Response to Planning application from Hertfordshire County Council (T and CP GDP Order 2015)

District ref: 6/2022/1444/FULL
HCC ref: WH/12980/2022
HCC received: 11 July 2022
Area manager: Matthew Armstrong
Case officer: Steven Knight

12 HARPSFIELD BROADWAY HATFIELD AL10 9TF

Erection of part two, part three storey rear extension with mansard roof and conversion to 8 flats comprising 6 x 2-bed and 2 x studio

DRAWING TITLE		
Proposed - Ground Floor		
CLIENT		
Mr Mak		
DRAWING No.	SCALE @ A3	Drawn by:
PR-P001	1:100	Faye

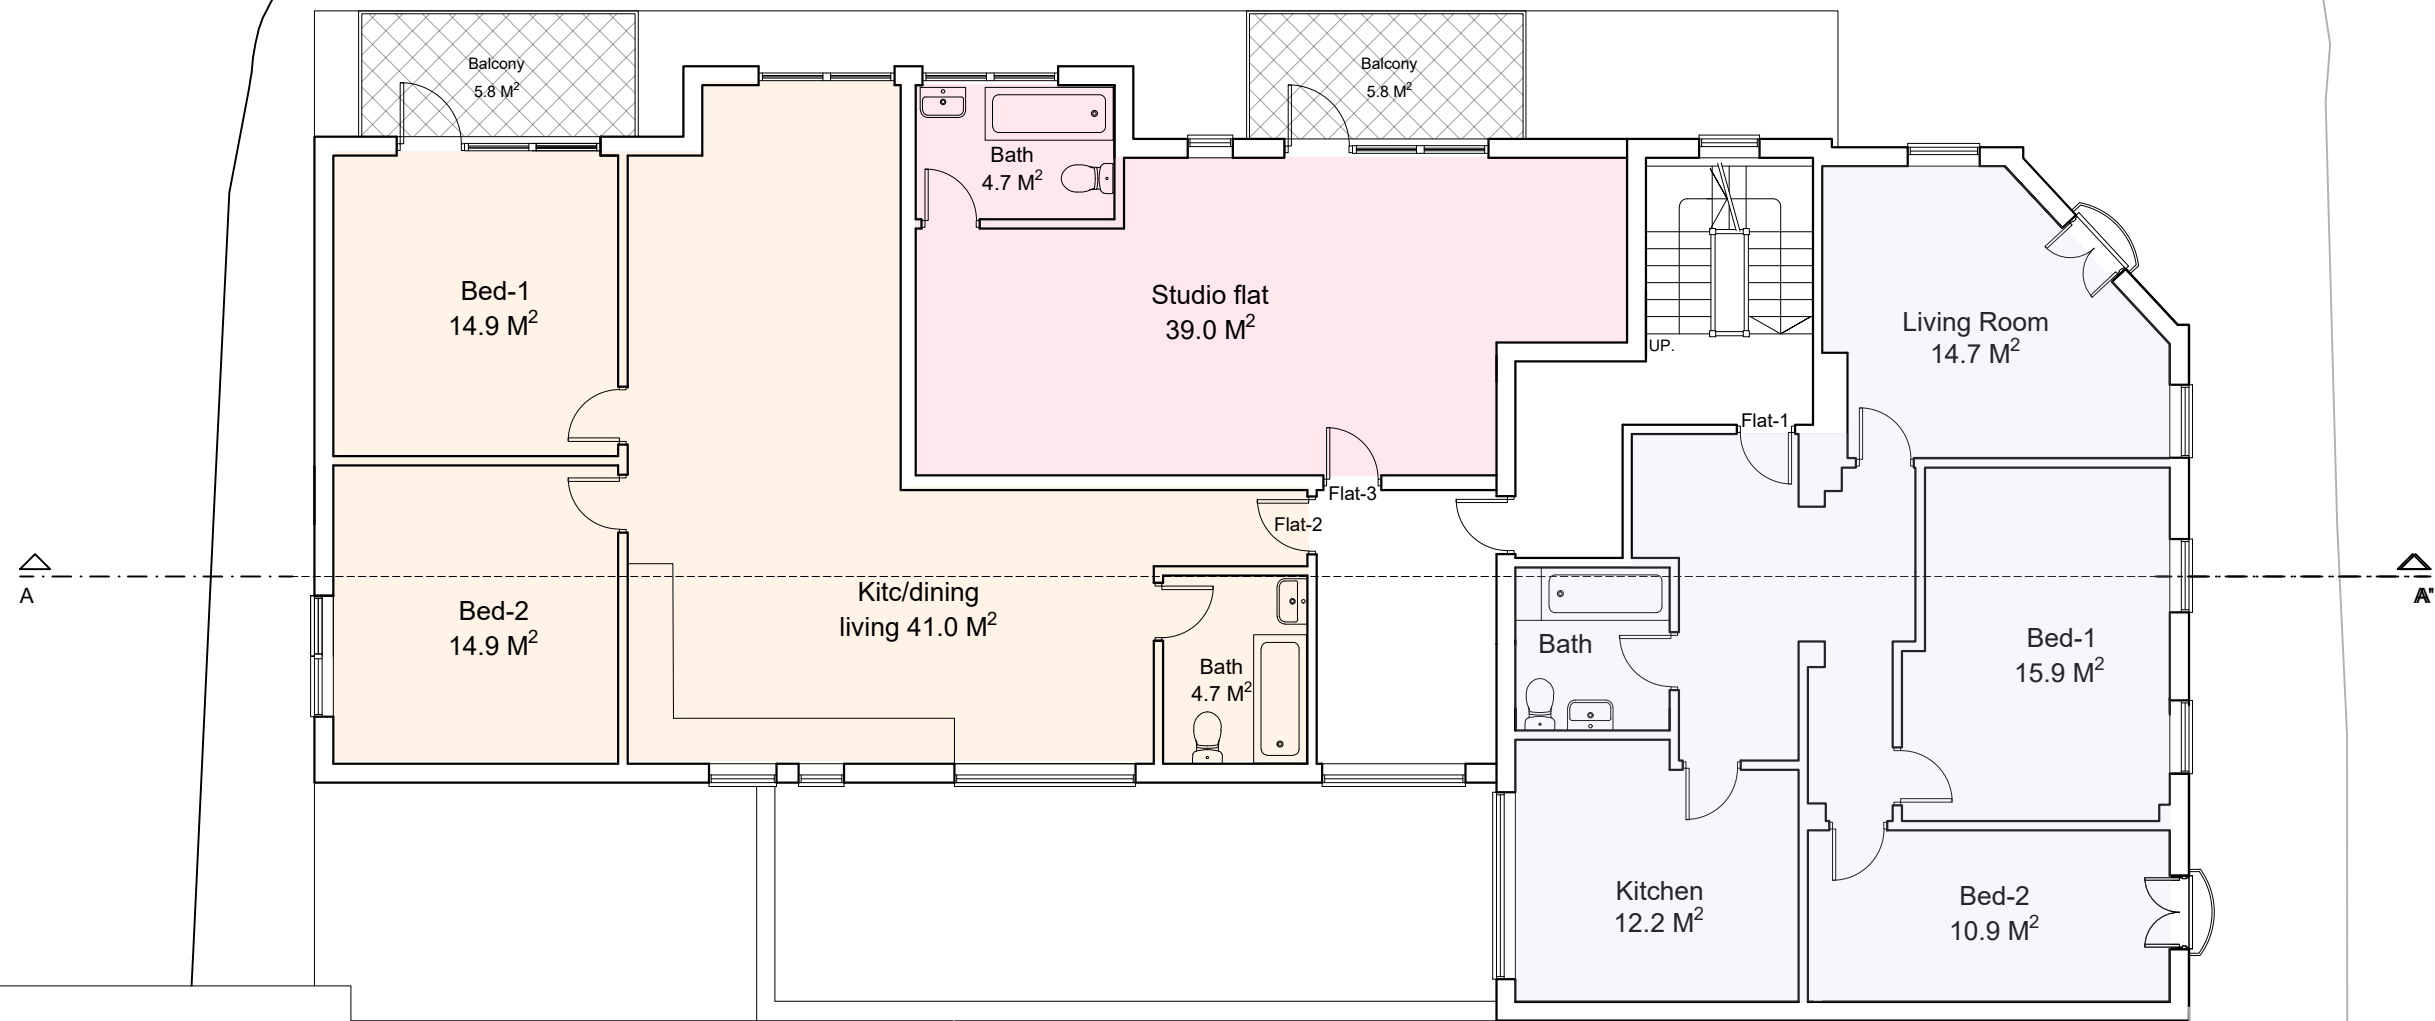
The applicant has proposed eight cycle parking spaces for the flats, one per unit, and five for the bar for both staff and customer use. This provision is in line with the LPA's parking standards. Detailed designs should be conditioned to ensure that the spaces are compliant with the guidance in LTN 1/20 and they can be accommodated within the areas allocated for cycle storage.

The drawings show that bins will be stored in an undercroft area on the ground floor facing Jetliner Way. The LPA should be satisfied that waste collection vehicles can access and stop on Harpsfield Broadway and that a suitable dropped kerb is available for larger communal bins. Whilst vehicles may be able to access the bin store from Jetliner Way, vehicles must be able to turn around and re-join Comet Way in a forward gear. This may or may not be possible depending on the long plans for the bus station to the west of the site.
